From: Archer, Heather <Heather.Archer@highwaysengland.co.uk>
Sent: 05 February 2021 14:03
To: Planning
Subject: Response 5 February 2021 Former Volkswagen Van Centre, Comet Way, Hatfield, AL10 9TF Planning application 6/2020/3222/MAJ

Site: Former Volkswagen Van Centre, Comet Way, Hatfield, AL10 9TF

Development: Demolition of existing buildings and construction of new building comprising 118 residential apartments, layout of parking areas, landscaping, electricity substation and ancillary development

Highways England's Ref No: #90231 / 12317

Stantec Drawing 47179/4001/002 Surface Water Drainage Strategy

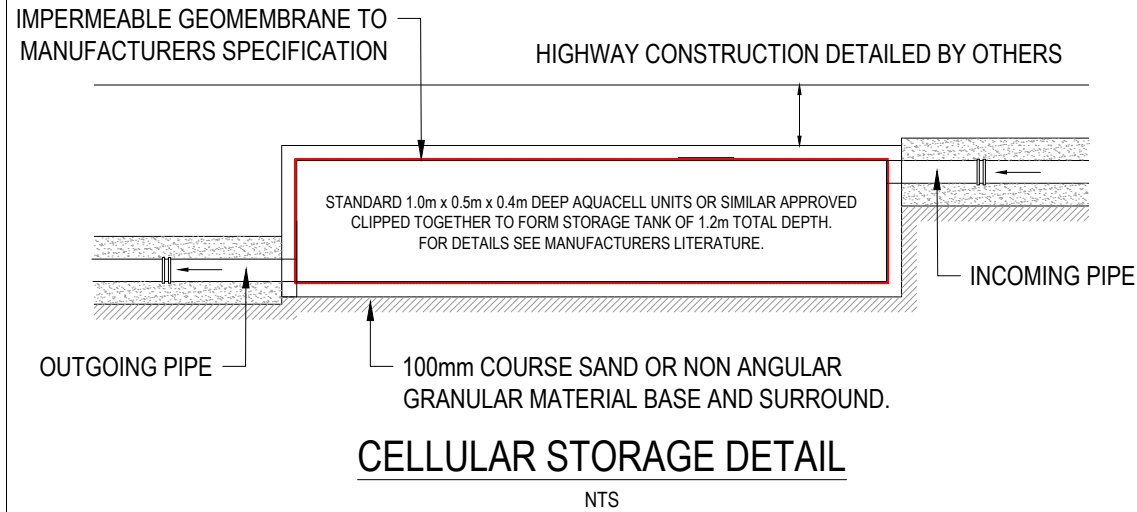
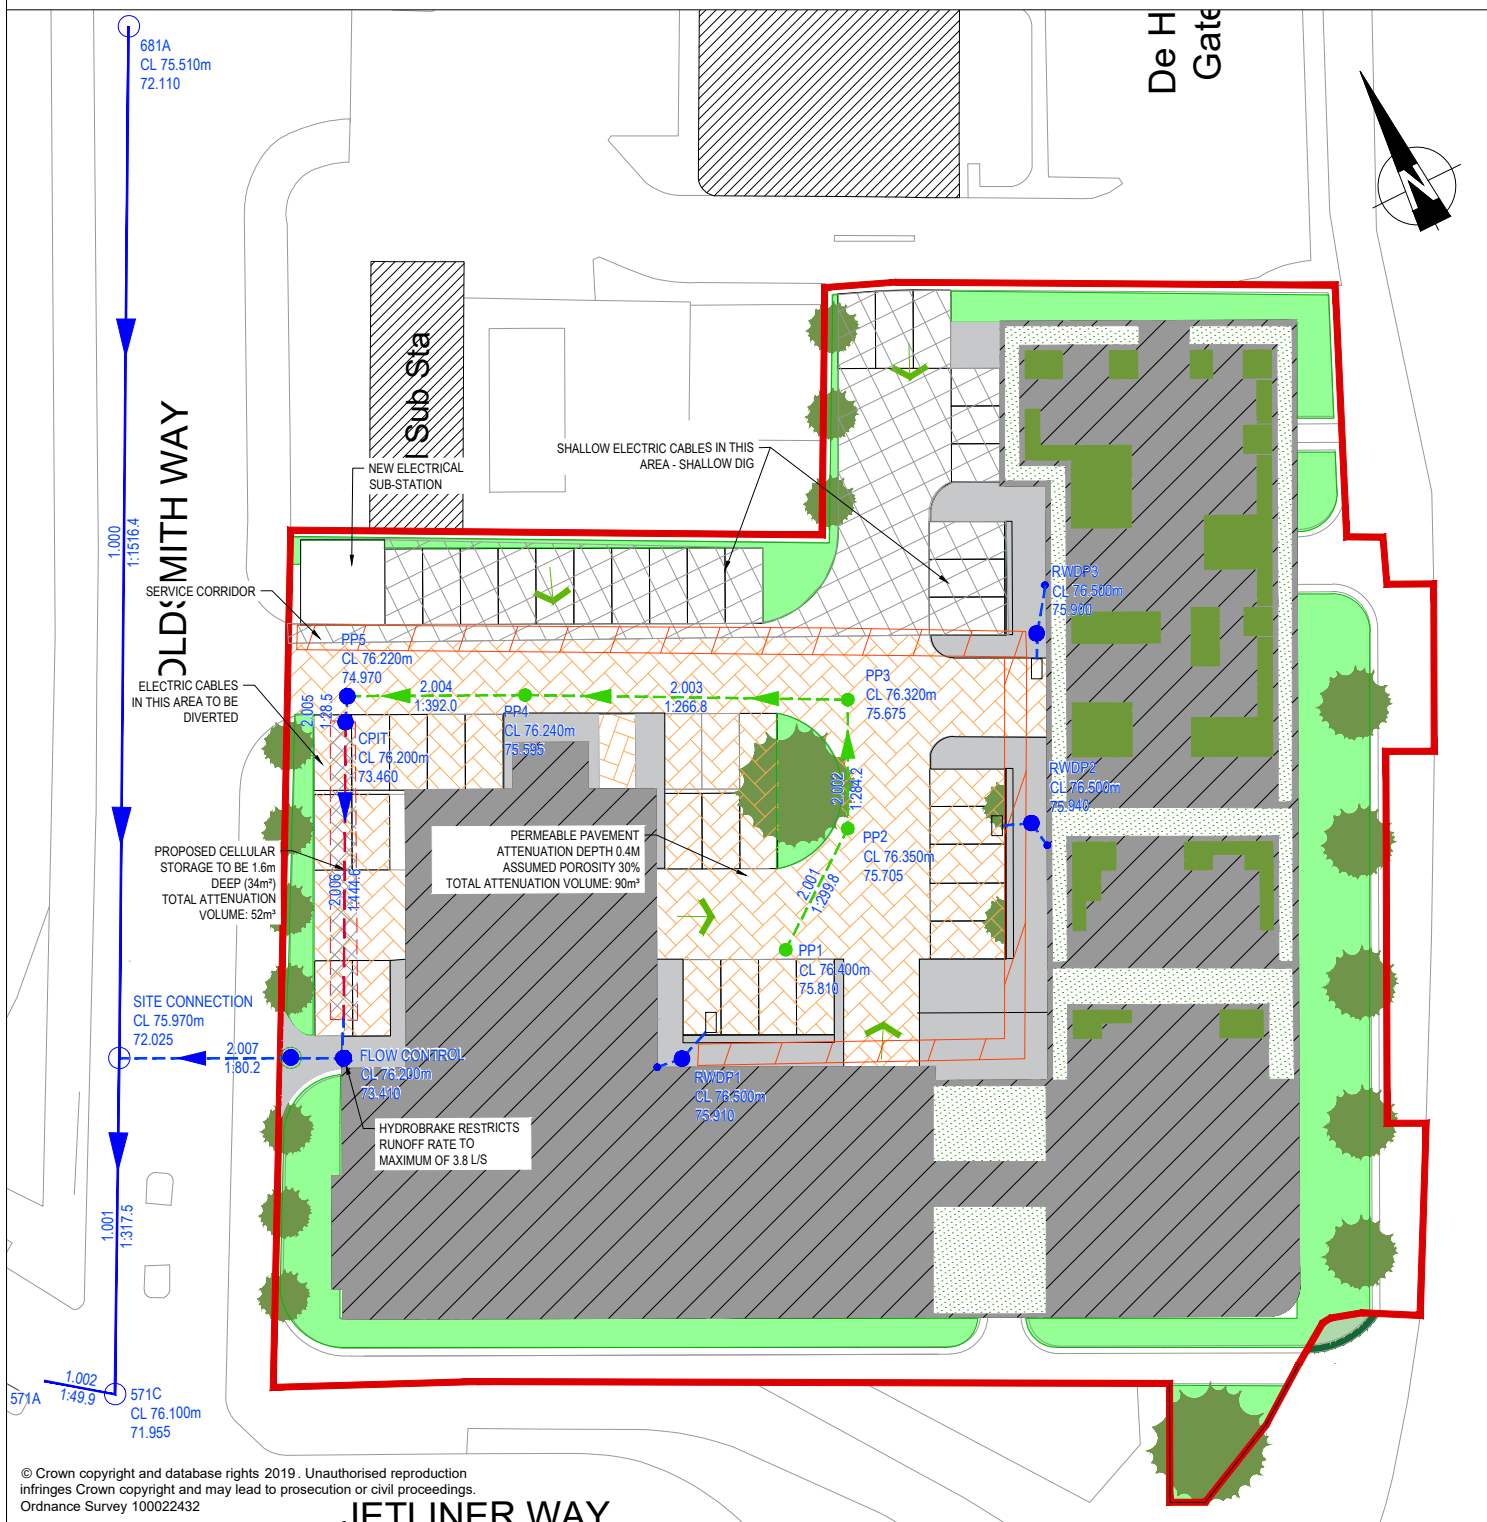
Further to our queries dated 21 January 2021, to which we are awaiting a response, I have received additional comments from Highways England's service providers on drainage matters in the planning application. After review of the Drainage Statement, it is noted that exceedance routes have been indicated in the design, and it is proposed that exceedance flows up to the 1 in 100 year event will be managed on site. However it is not clear what happens to the flow in events greater than 1 in 100 years. (Section 4.5.8).

Could the applicant please provide further information on how they intend to manage flow in events greater than 1 in 100 years.
